**Consultation Response from KC,
Trees****2022/92081 Land at, Huddersfield Road/Leeds Road, Birstall, Batley, WF17 9AA****Demolition of existing buildings and erection of retail food store with associated parking and landscaping****Date Responded: 18/07/22****Responding Officer: Nick Goddard****Responding Ref: CA57**

Title: Proposed Site Plan
Client: Wharfedale Ltd.

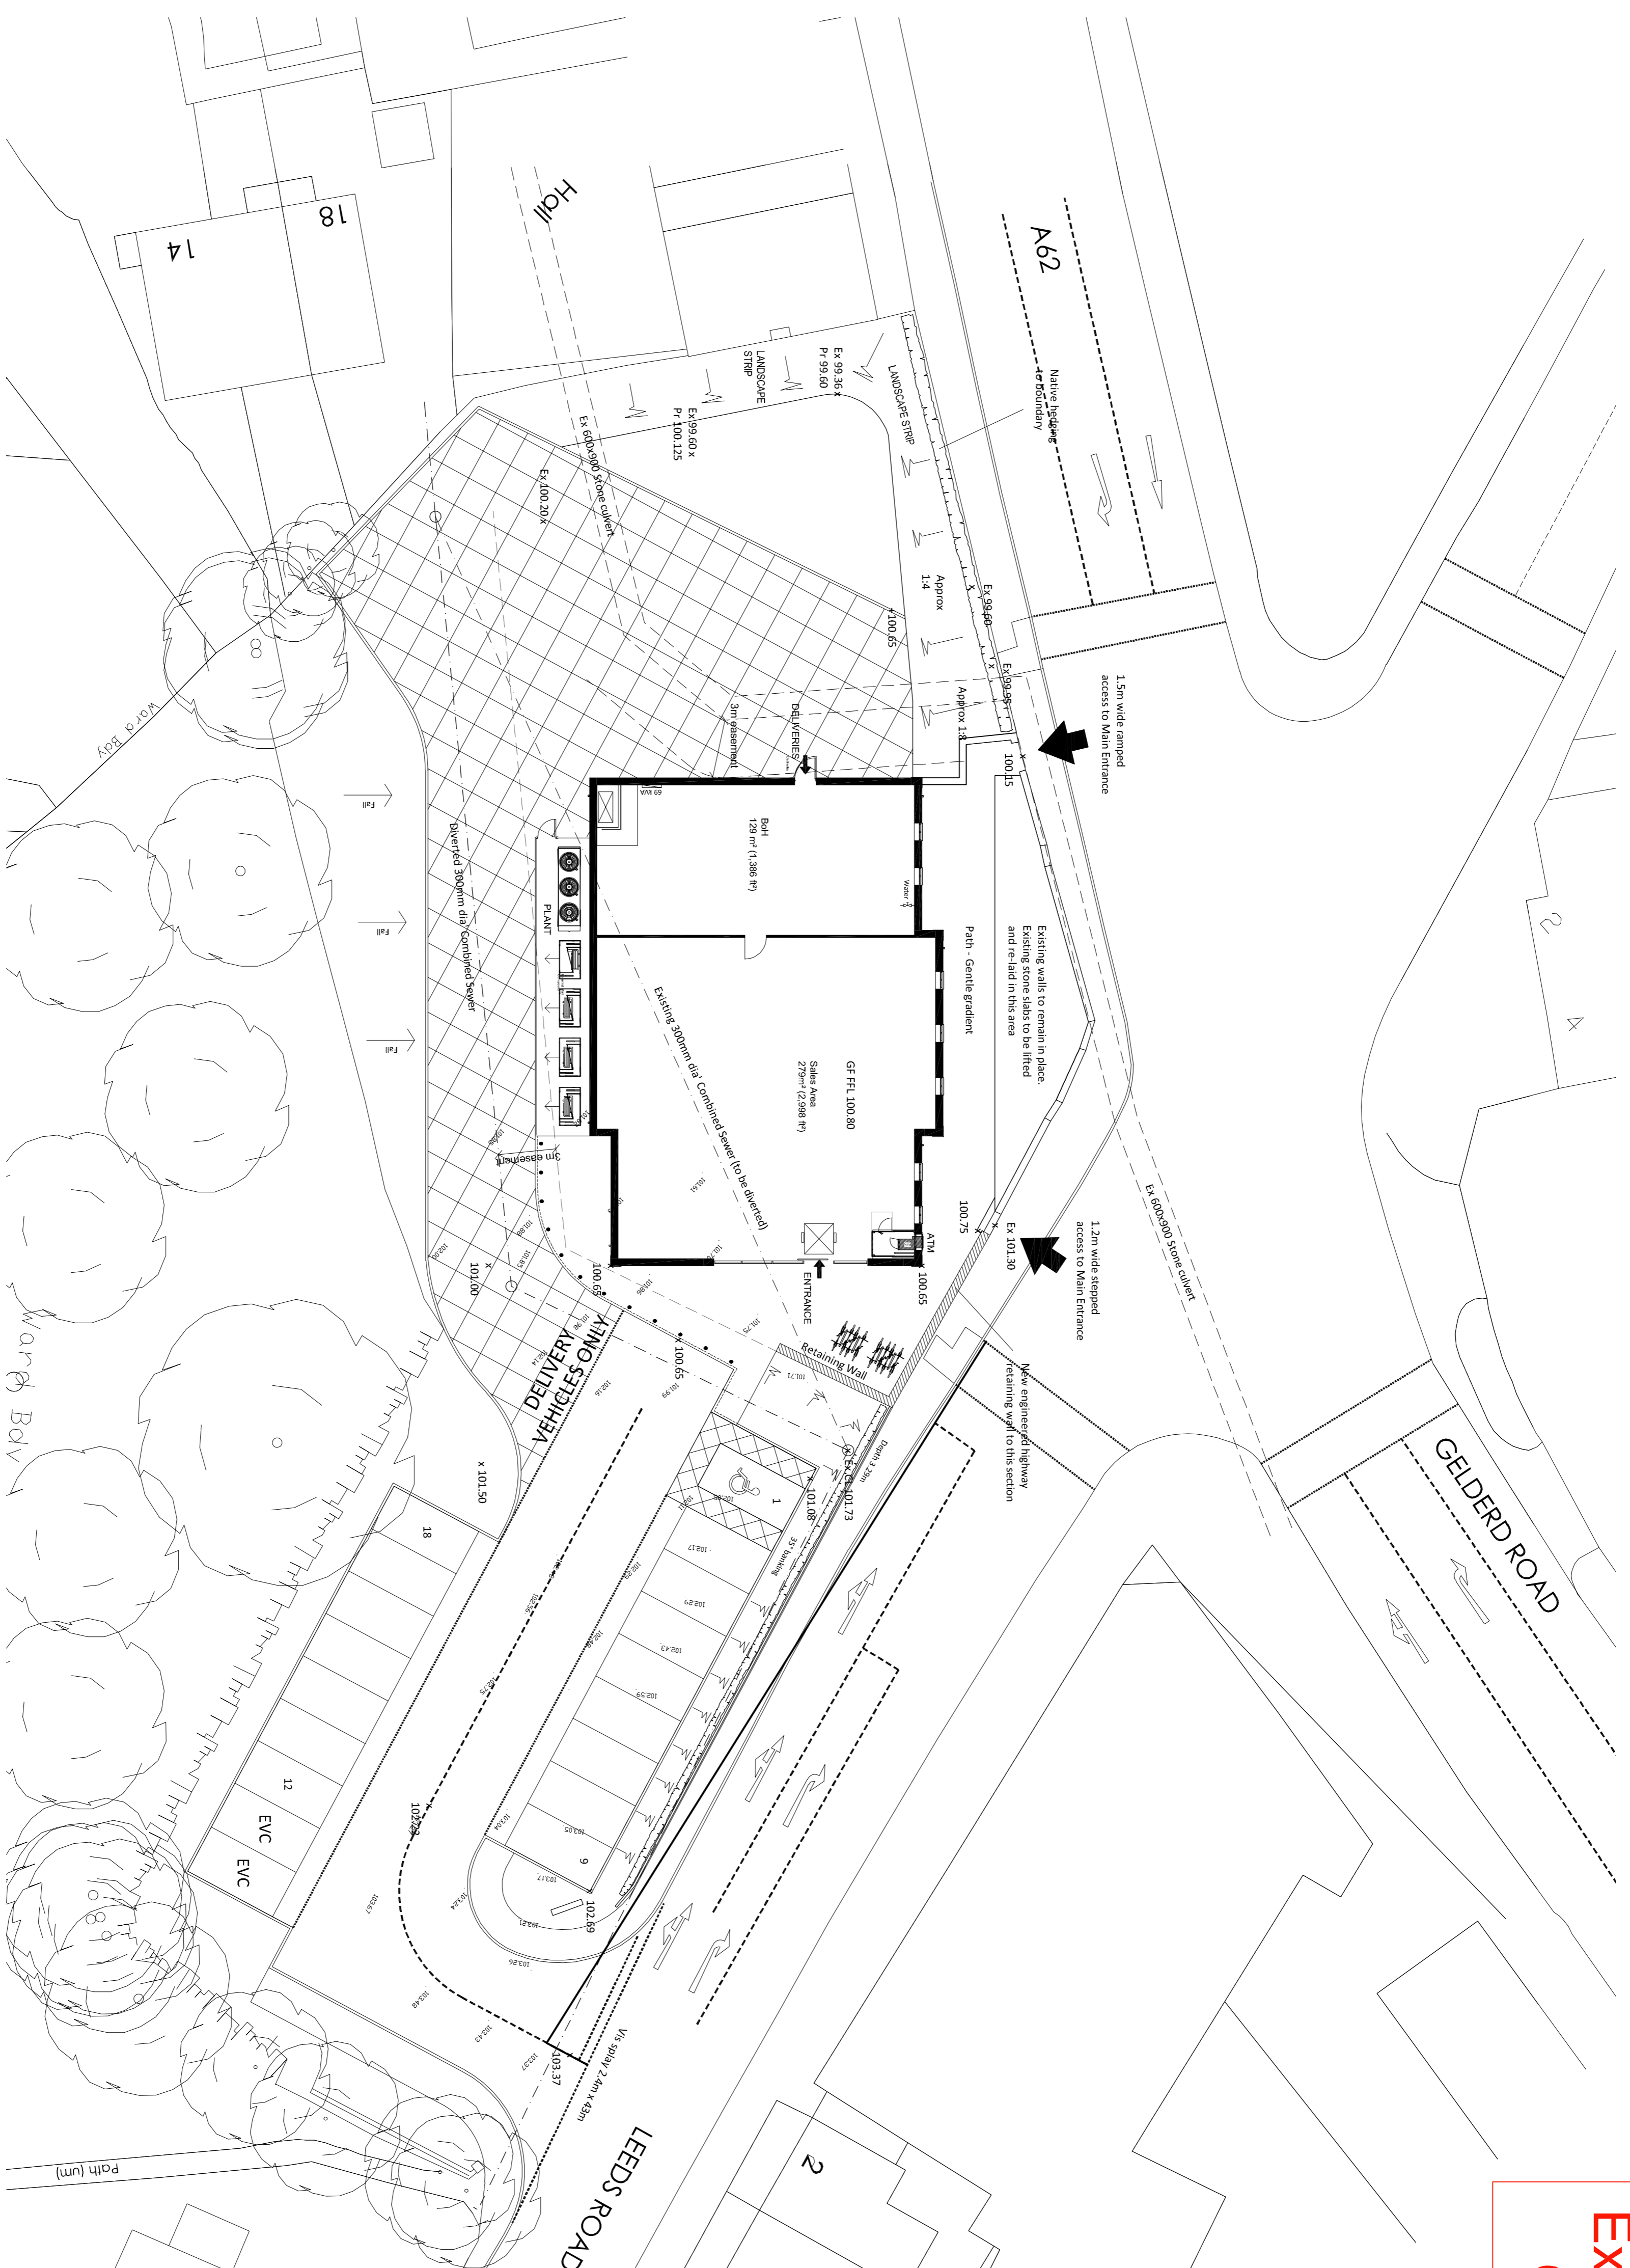
The proposals require the removal of two trees to facilitate the construction neither of which would warrant protection by a TPO and should not be a constraint on development of this site.

For the reasons given above I would have no objection to the proposals but would suggest a condition for landscaping detail to provide improved tree cover against the Leeds Road and Huddersfield Road.
